Submission No.			309	
Organisation Name or Name of Submitter			Vincent Harris and others 2 (represented by Marston Planning Consultancy) [Stephen Smith / Alex Smith / Robin Smith / Lauren Smith, Sheila Boyd / Francis Mackey / Jacqueline McElhinney]

Drawing Title	METROLINK GLASNEVIN HEAVY RAIL TRACK REALIGNMENT	Drawing Status	S0
Drawing N°	ML1-JAI-SRD-MS11_XX-DR-Y-01001	Plan Drawing N°	ML-ST 304 N-09
Scales	Original Size A1 AS SHOWN	Sheet	1 of 5

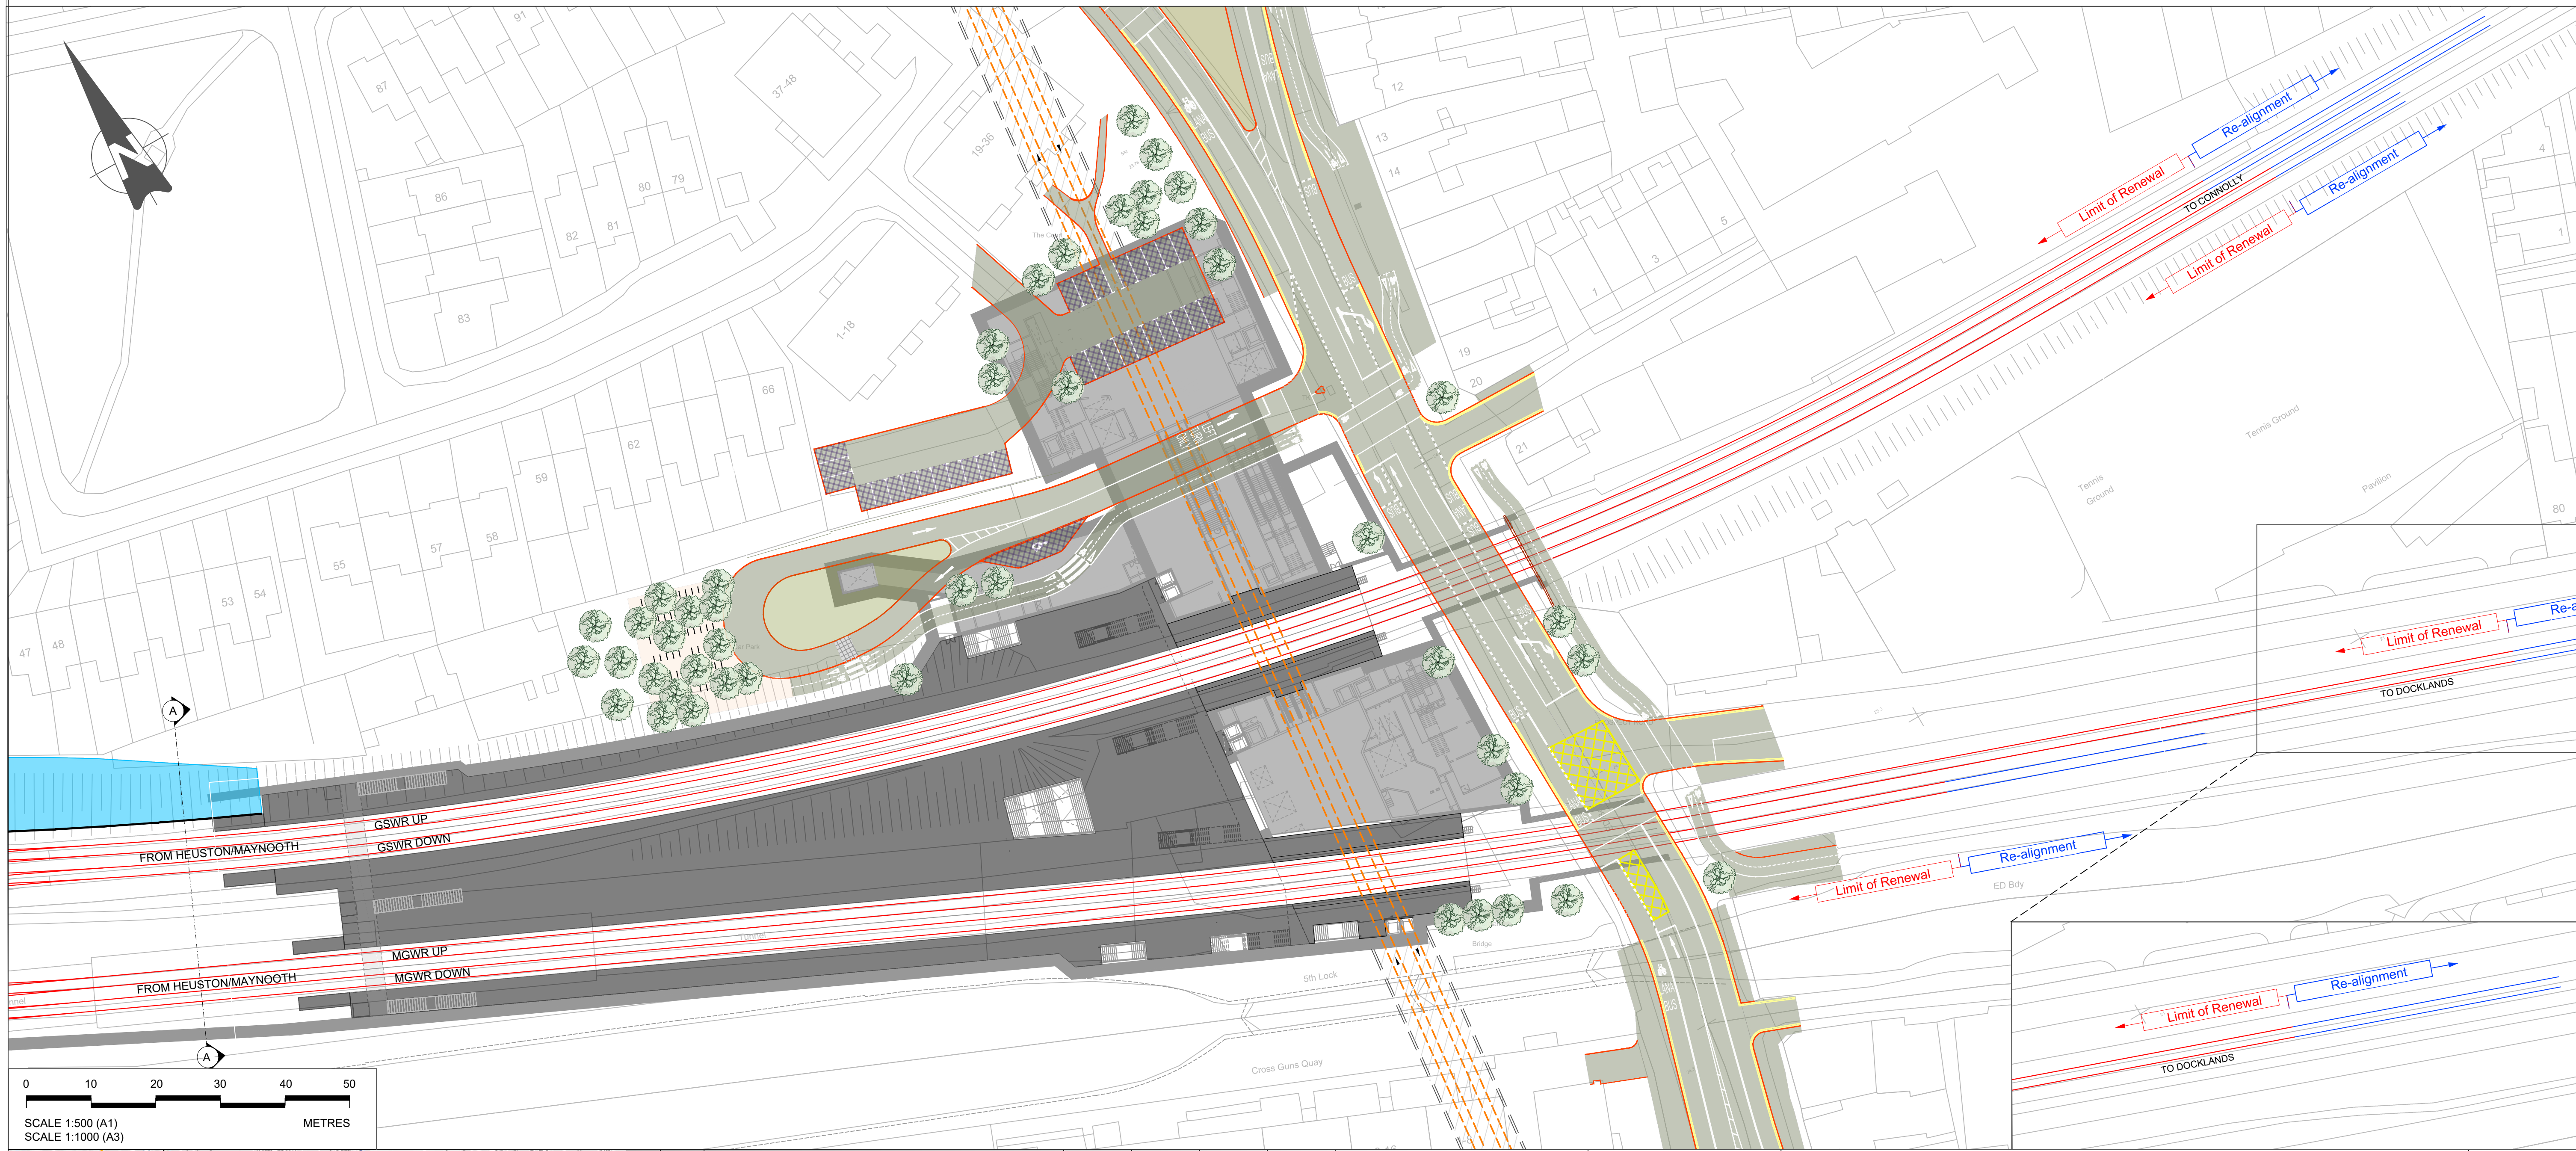
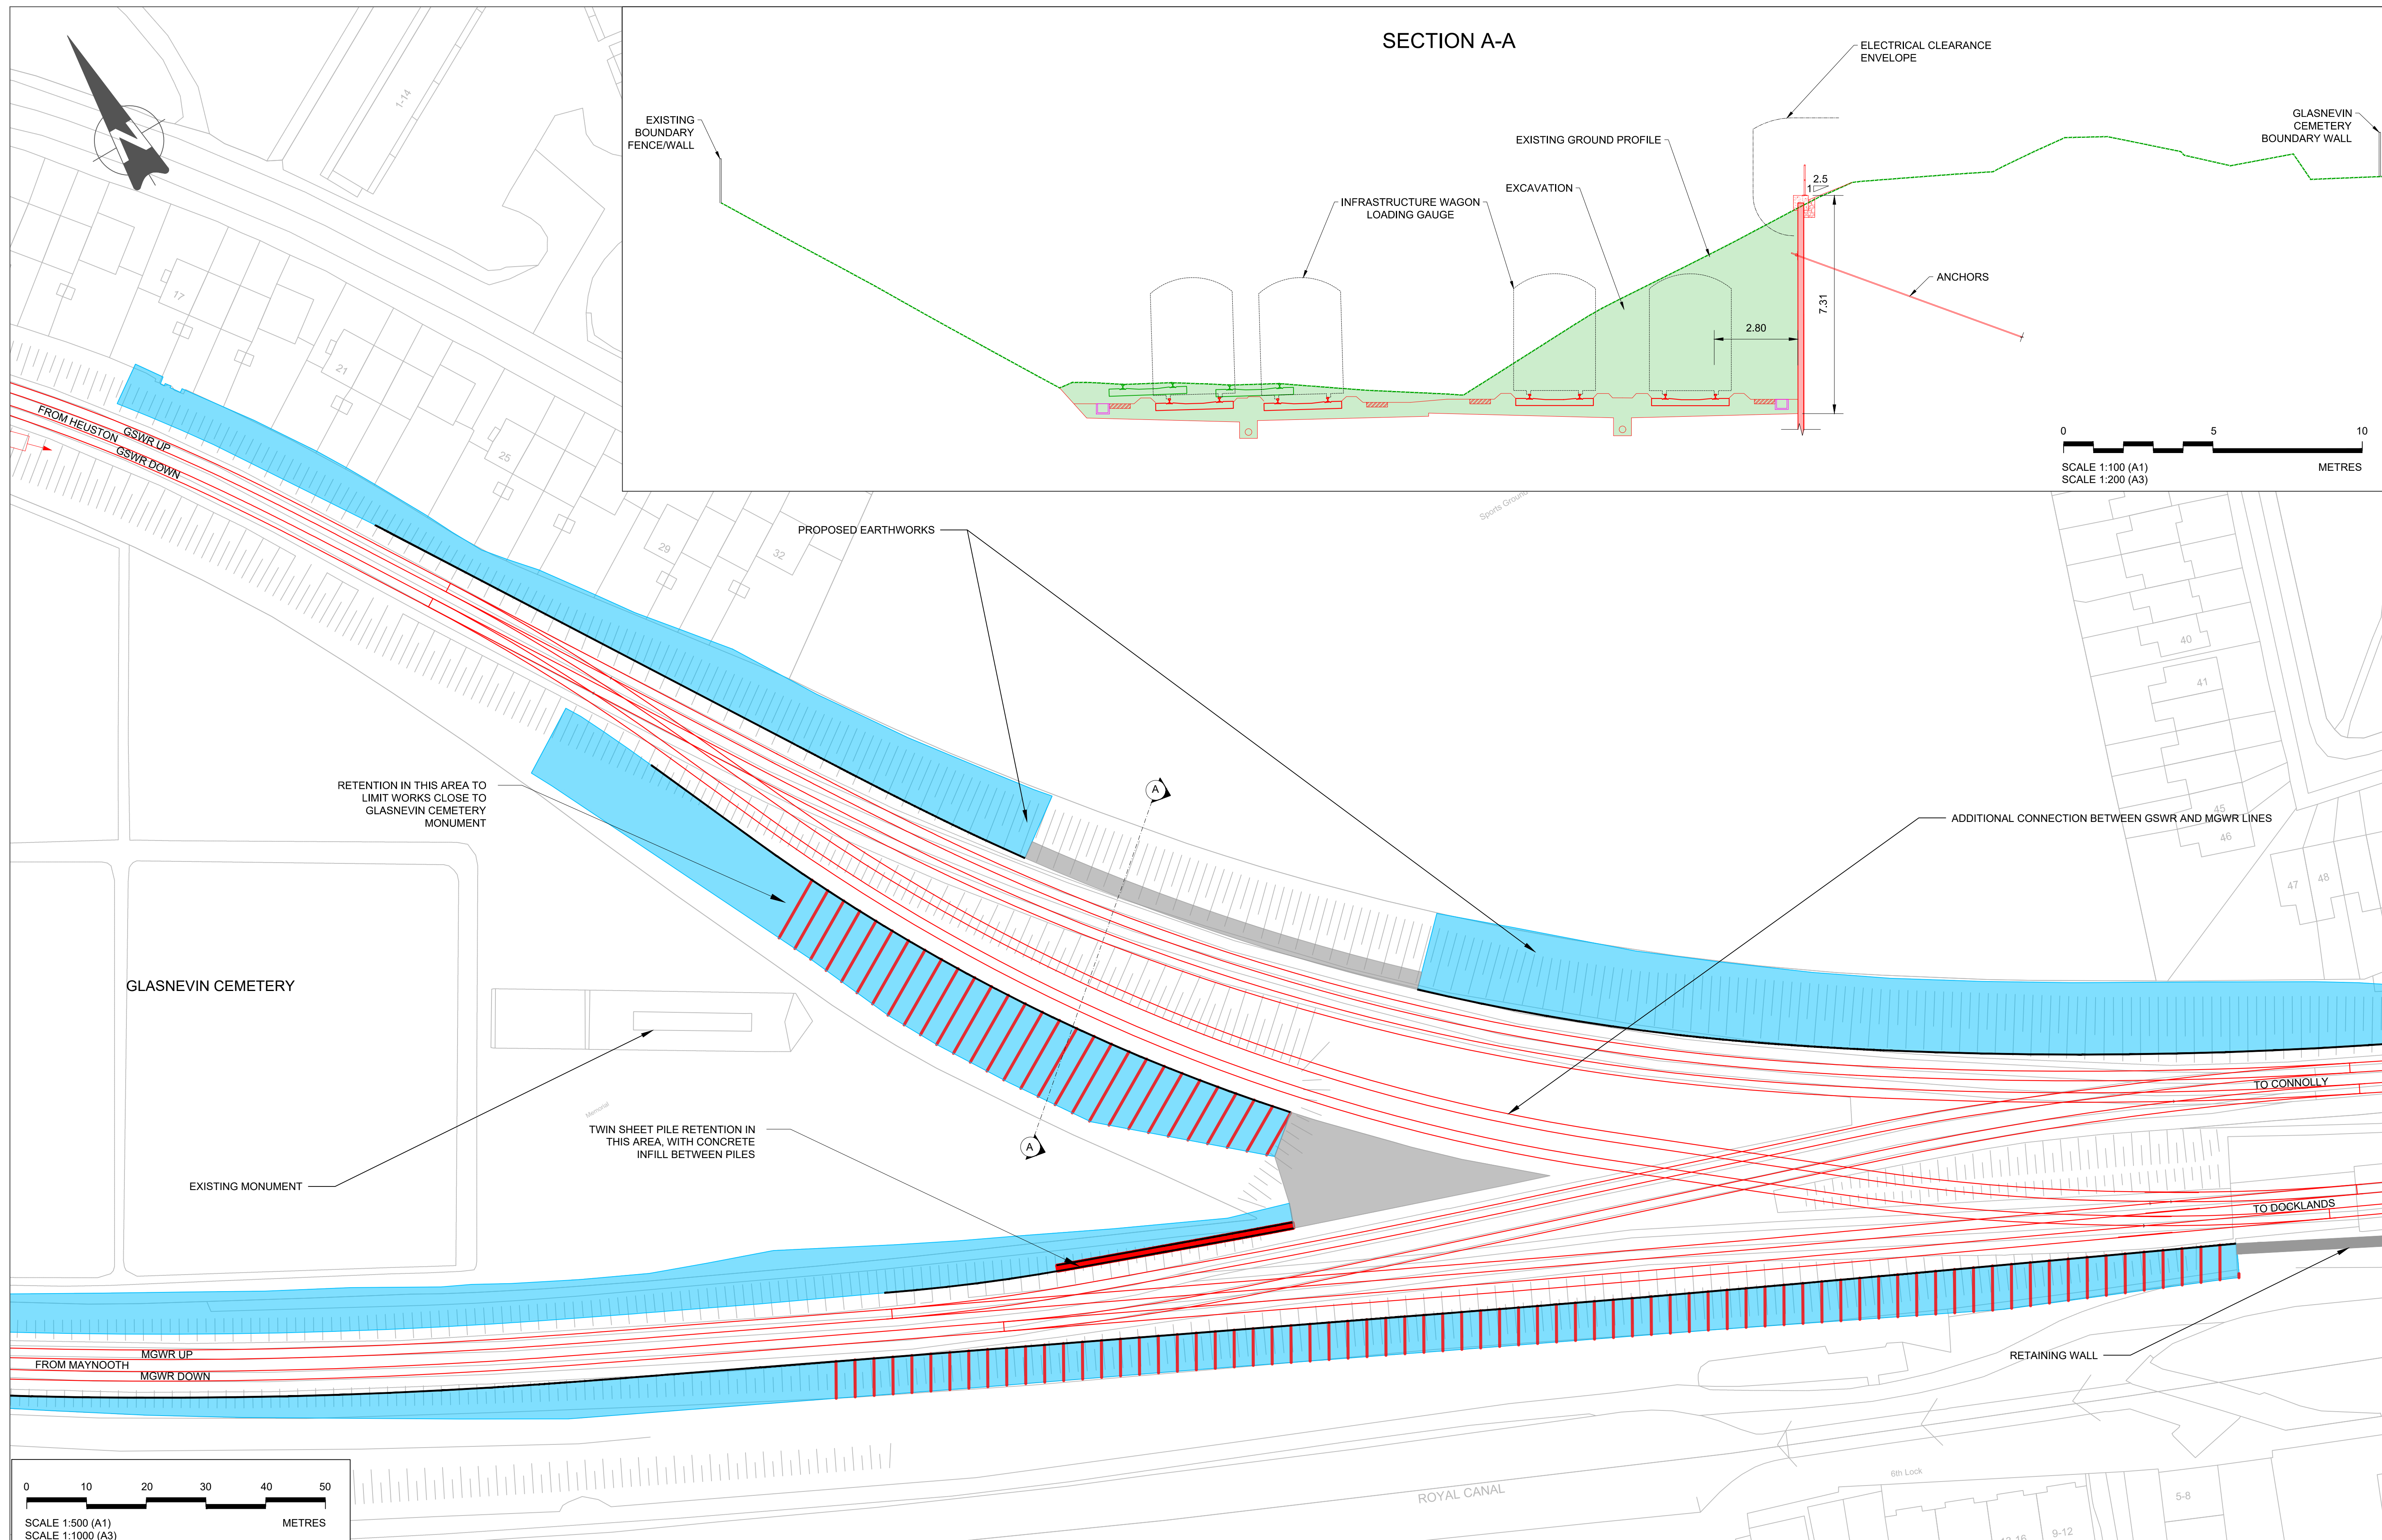
3	Letter	1	We noted in our original submission that the interlinked works with the existing main line will require the western commuter line (that backs onto the Coke Oven Cottages) to be closed for a period of 21 months. Section 5.10.6 of the EIAR indicates that the train track will be lowered by c. 2m although the alignment drawings provide no detail as to where and along which stretch of the railway this reduction will occur. A drawing is noted as indicating as proposed earthworks to the rear of the Coke Oven Cottages. No detail is provided as to the nature and extent of these earthworks.	<p>Please refer to Response (2) in relation to the works to the Irish Rail tracks running past the cottages which will be undertaken as part of a full line closure of 21months as noted in EIAR Appendix 5.5 – Glasnevin Station Construction Report, section 1.</p> <p>The reference to the 2m lowering relates to the rail tracks at Glasnevin Station. The track will be laid on a gradient to tie in to the existing tracks just north-west of Coke Oven Cottages as shown on the drawings noted in Response (2) above.</p>
